From: Simon Davis
Sent: 08 April 2021 14:09
To: Richard Stefanski [REDACTED]
Cc: Alex Burrows [REDACTED]
Subject: RE: BR/8/21/RES

Issue status:	☐ Outline proposals	☐ Production information	☐ Scheme design
	☐ Tender drawing	☐ Detail design	☐ Contract drawing
Scale:	Drawn:	Checked:	Date:
1:100 @A1	V. Botezat	R. Stefanski	24.11.2020
Job No:	Drawing No:	Revision:	
1468	PL 03

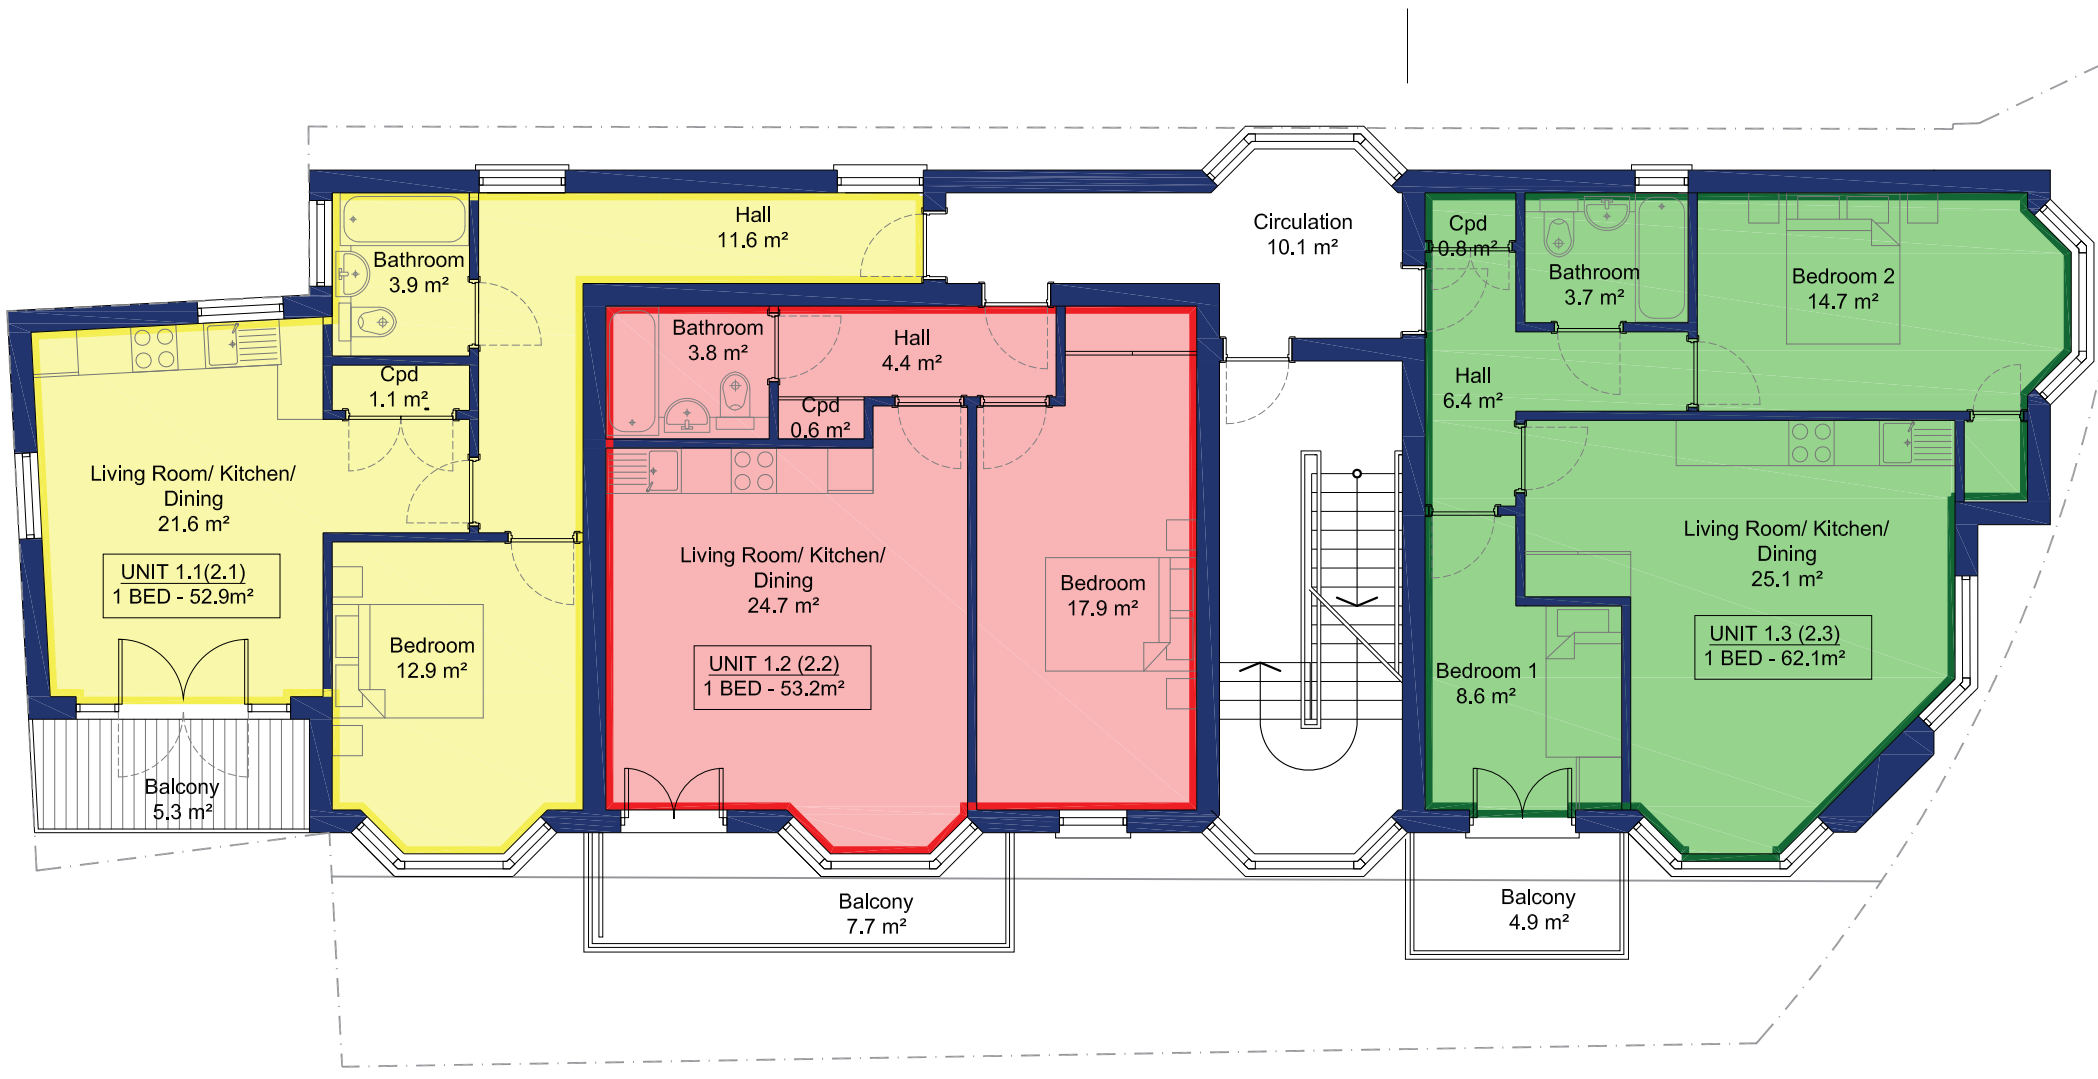
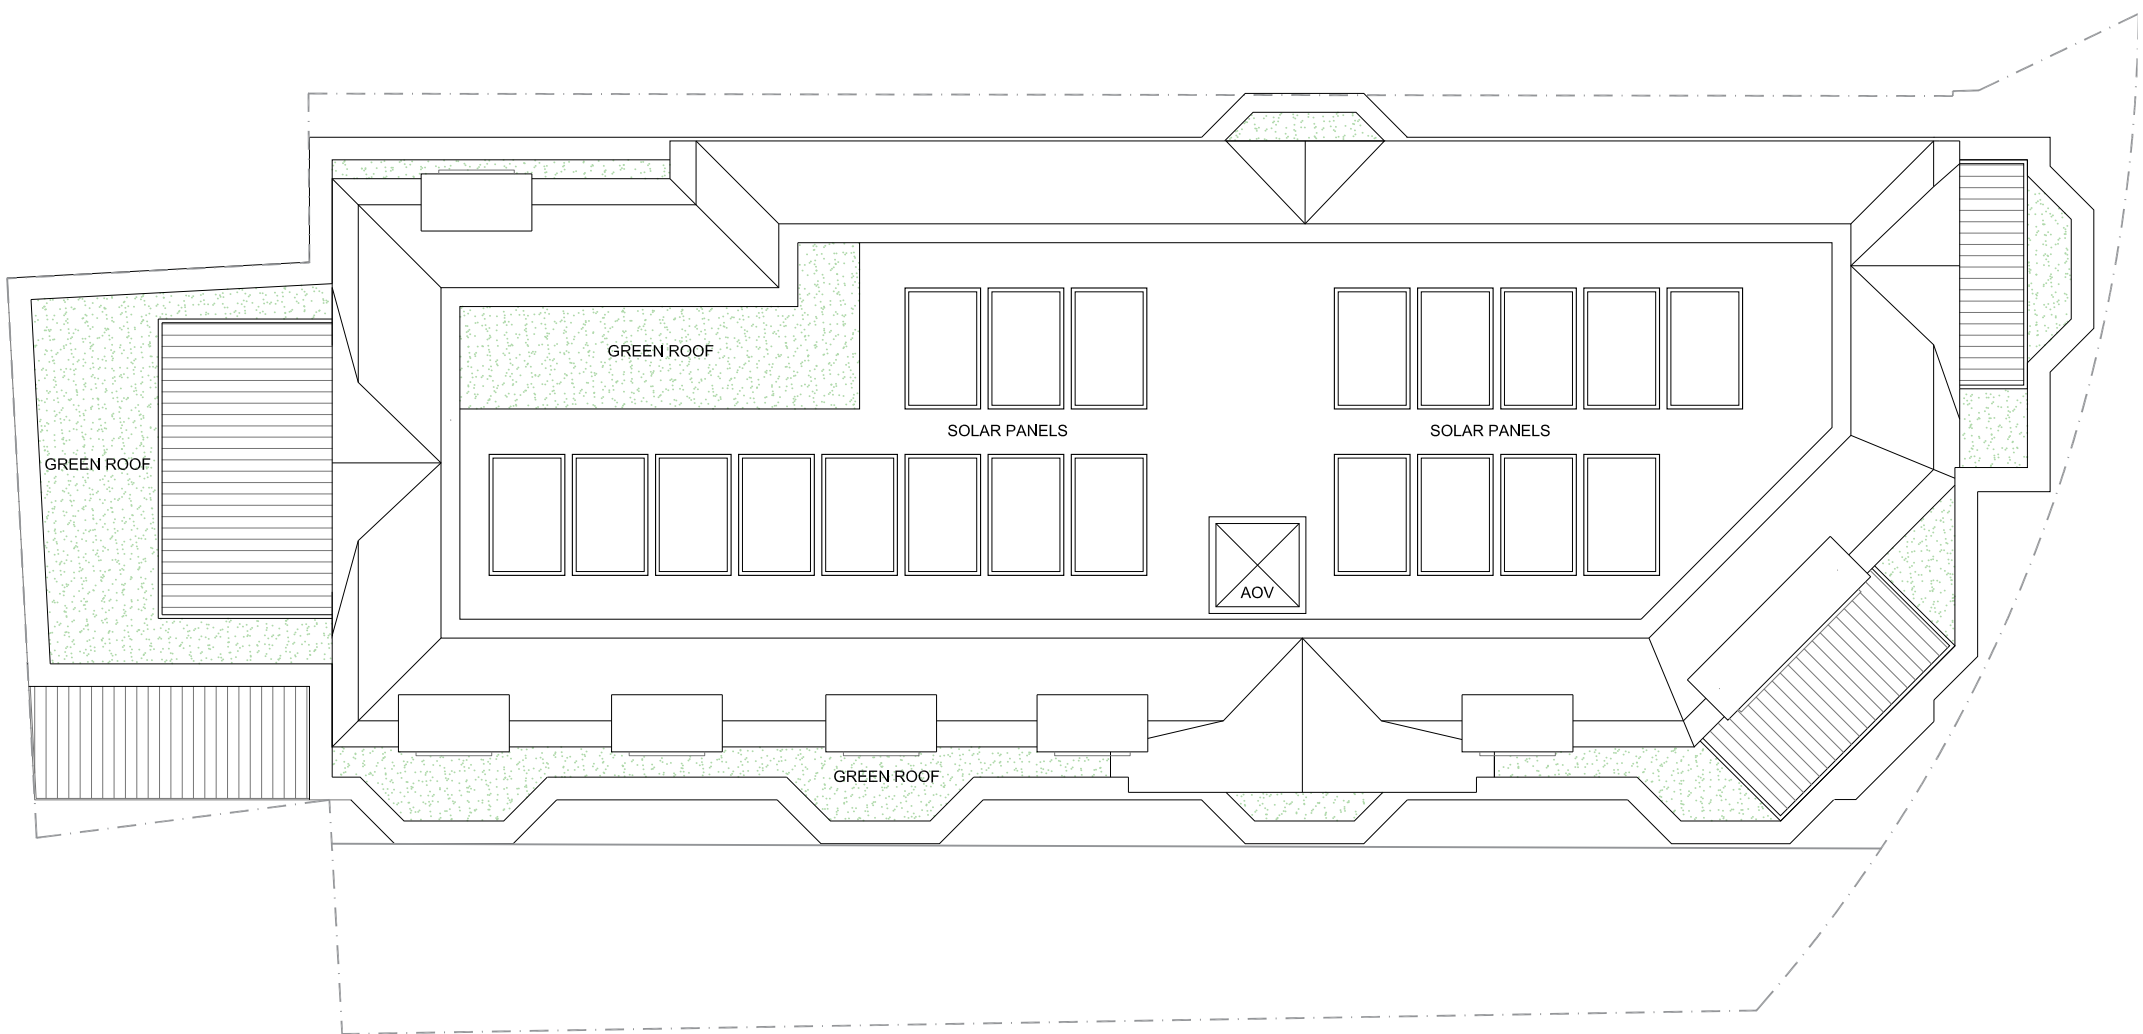
- Floor plan revised. Adjusted from a 5-person 3 bed to a 4-person 2 bed.
- Window located in the living/kitchen dining, along the north west elevation, kept fixed shut, standard thermal double-glazing (which provides a sound reduction of RRAIL = 36dB) will be sufficient to ensure compliance with the requirements of BS8233 for daytime and night time periods. The room benefits from openable windows along the south east elevation. The windows are large enough to provide adequate purge ventilation.
- Bedroom 1 & 2 are located, with openable windows along the south east elevation.

- Window located in the living/kitchen dining, along the north west elevation, kept fixed shut, standard thermal double-glazing (which provides a sound reduction of RRAIL = 36dB) will be sufficient to ensure compliance with the requirements of BS8233 for daytime and night time periods.. The room benefits from openable windows along the south east, and south west elevation. The windows are large enough to provide adequate purge ventilation.

With reference to Environmental Health's comments on the original application (BR/142/18/OUT), Environmental Health objects to this application as the layout has habitable rooms facing the railway which will mean that BS8233 will only be met if the windows are kept closed. This application therefore does not follow the principles of good acoustic design within ProPG.

Please note that this was raised at the outline stage and indeed formed part of an informative 12 on the decision notice. I therefore write to request that you amend the floor plans/building layout to remove habitable rooms from the elevation backing onto the railway line. Please provide amended plans by the 17th February or if you need longer, advise me when you need until.
